LAND OFF OWL LANE, DEWSBURY

TECHNICAL NOTE: RESPONSE ON

TTHC Ref: M19110-01 TN01
Date: October 2019

- 1.2 The application is for the erection of 252 dwellings on vacant greenfield land (Planning Reference: 2019/62/92787/E). Given that the Site is currently undeveloped land, all impacts that would be generated by the development would be new impacts and would be new to the area.

OWL LANE, CHIDSWELL
PROPOSED RESIDENTIAL DEVELOPMENT
PROPOSED SITE ACCESS

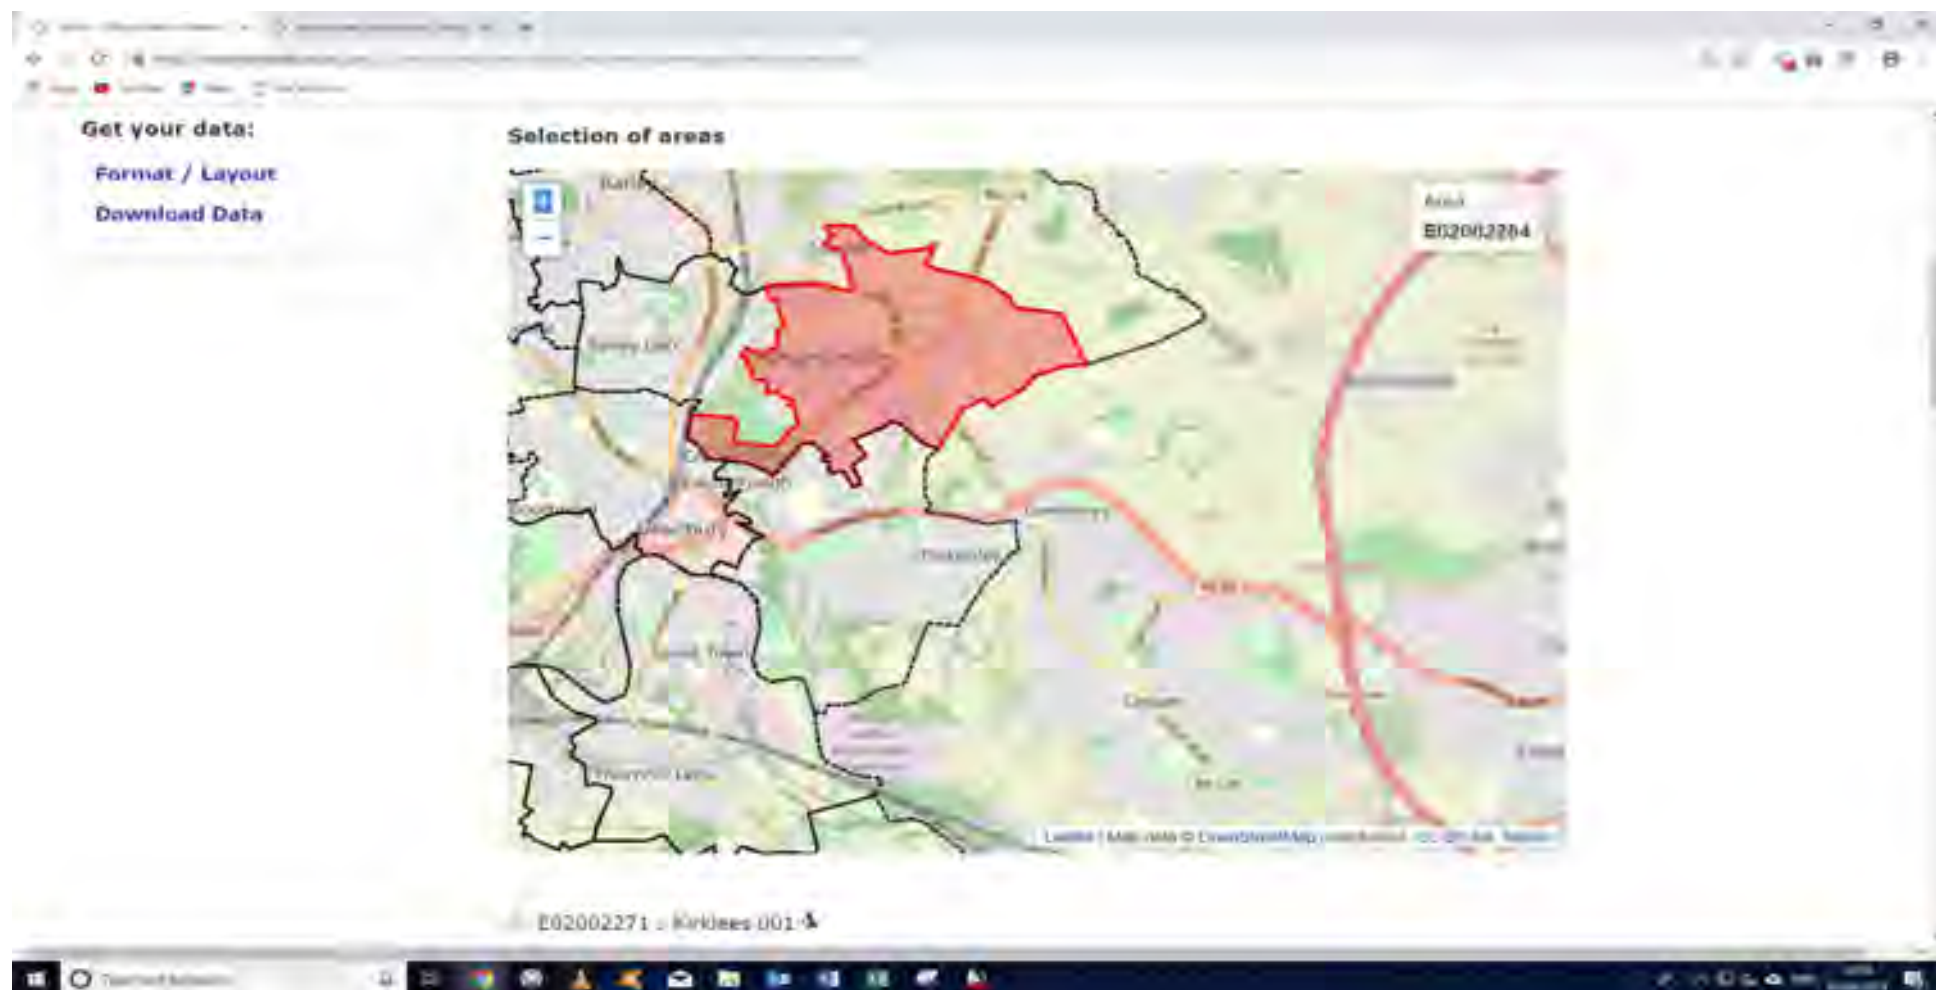
- 4.5 A review of the junction measurement raises a query regarding the data input for Owl Lane South. The entry width for this arm has been input as 7.5m, comparison to 7.0m for both the Site access arm and Owl Lane North. Our measurements find no material difference in the entry widths of the three arms; we therefore question whether the entry width of Owl Lane South has been measured or input correctly. It appears that the model assumes a greater road width than would actually be the case.

- 4.7 Owl Lane South is the 'critical arm' of the junction in the AM peak; the TA shows that the approach is operating at theoretical capacity, with an RFC of 0.84. If the geometric data input for this approach are incorrect in the junction model, and provide greater junction capacity than would actually be the case, the junction would therefore operate with a lower capacity than shown in the TA. The Owl Lane South approach would likely be 'exceeding capacity' in that instance.

- 4.8 The Applicant should therefore make the source CAD drawing available for measurements to be taken, or alternatively, they could provide an annotated drawing that identifies the measurements they input to the junction model.

- 4.9 A review of the model output has identified that 'lane starvation' could occur at the Site access roundabout in reality. The model results for the Evening Peak, show that the Owl Lane North approach would have a queue of over three vehicles. A review of the TA site layout plan shows the space available would accommodate approximately three vehicles, before the arrival of a fourth vehicle would cause it to block the ahead movement, affecting traffic flows through the junction.
- 4.10 Once the trip distribution work required (as detailed above) has been undertaken, there is the potential for additional development trips to enter the Site from the north. This would therefore increase the potential for lane starvation and should be reviewed carefully once the updated flow work and subsequent re-modelling has been undertaken.

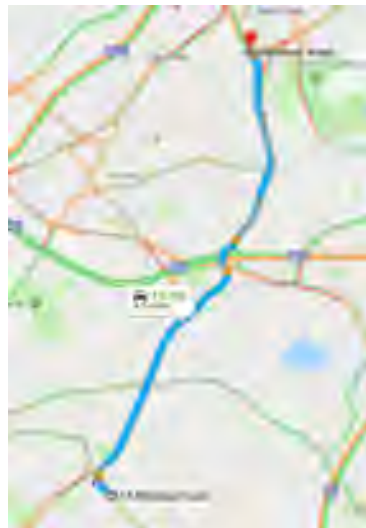
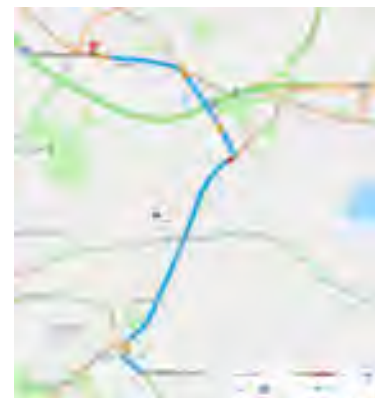
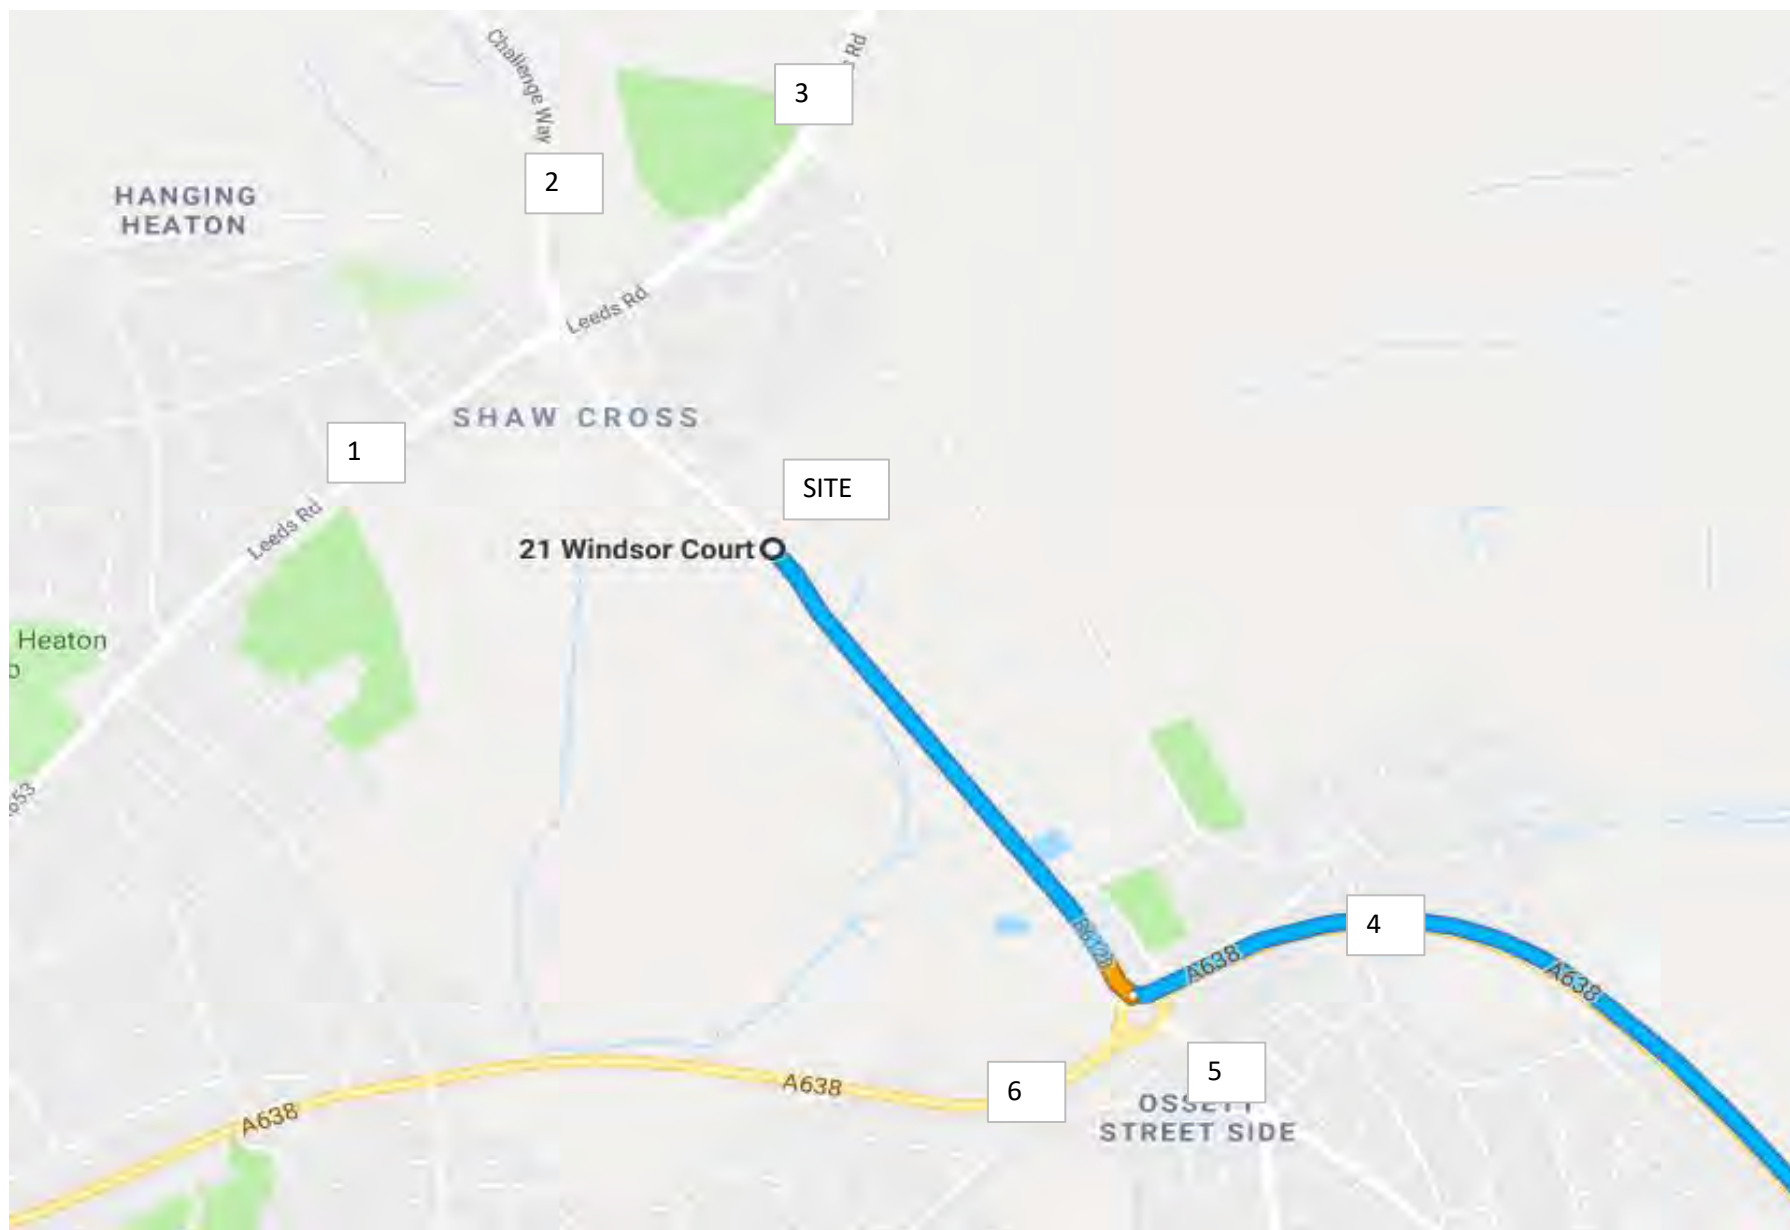
- 3.1 The visual quality of the census distribution information included within the TA (Appendix D of the TA) is poor and is, in parts, illegible. It is, therefore, hard to interpret anything meaningful from the graphics provided as justification for the decisions implemented within the census data distribution process.

- 3.5 This review has identified that certain census data has been omitted from the traffic distribution calculations; only seven MSOAs in Kirklees (out of 59) were accounted for and just three MSOAs (out of 112) in Leeds were accounted for.

- 3.7 The missing MSOAs represent potential employment destinations for the proposed development and should therefore be included within the traffic distribution calculations. This work therefore needs to be completed before it is possible to conclude on the suitability of the TA's traffic distribution works.

- **Kirklees:** approximately **44%** of the MSOA population has been excluded from the calculations; and
- **Leeds:** approximately **70%** of the MSOA population has been excluded from the calculations.
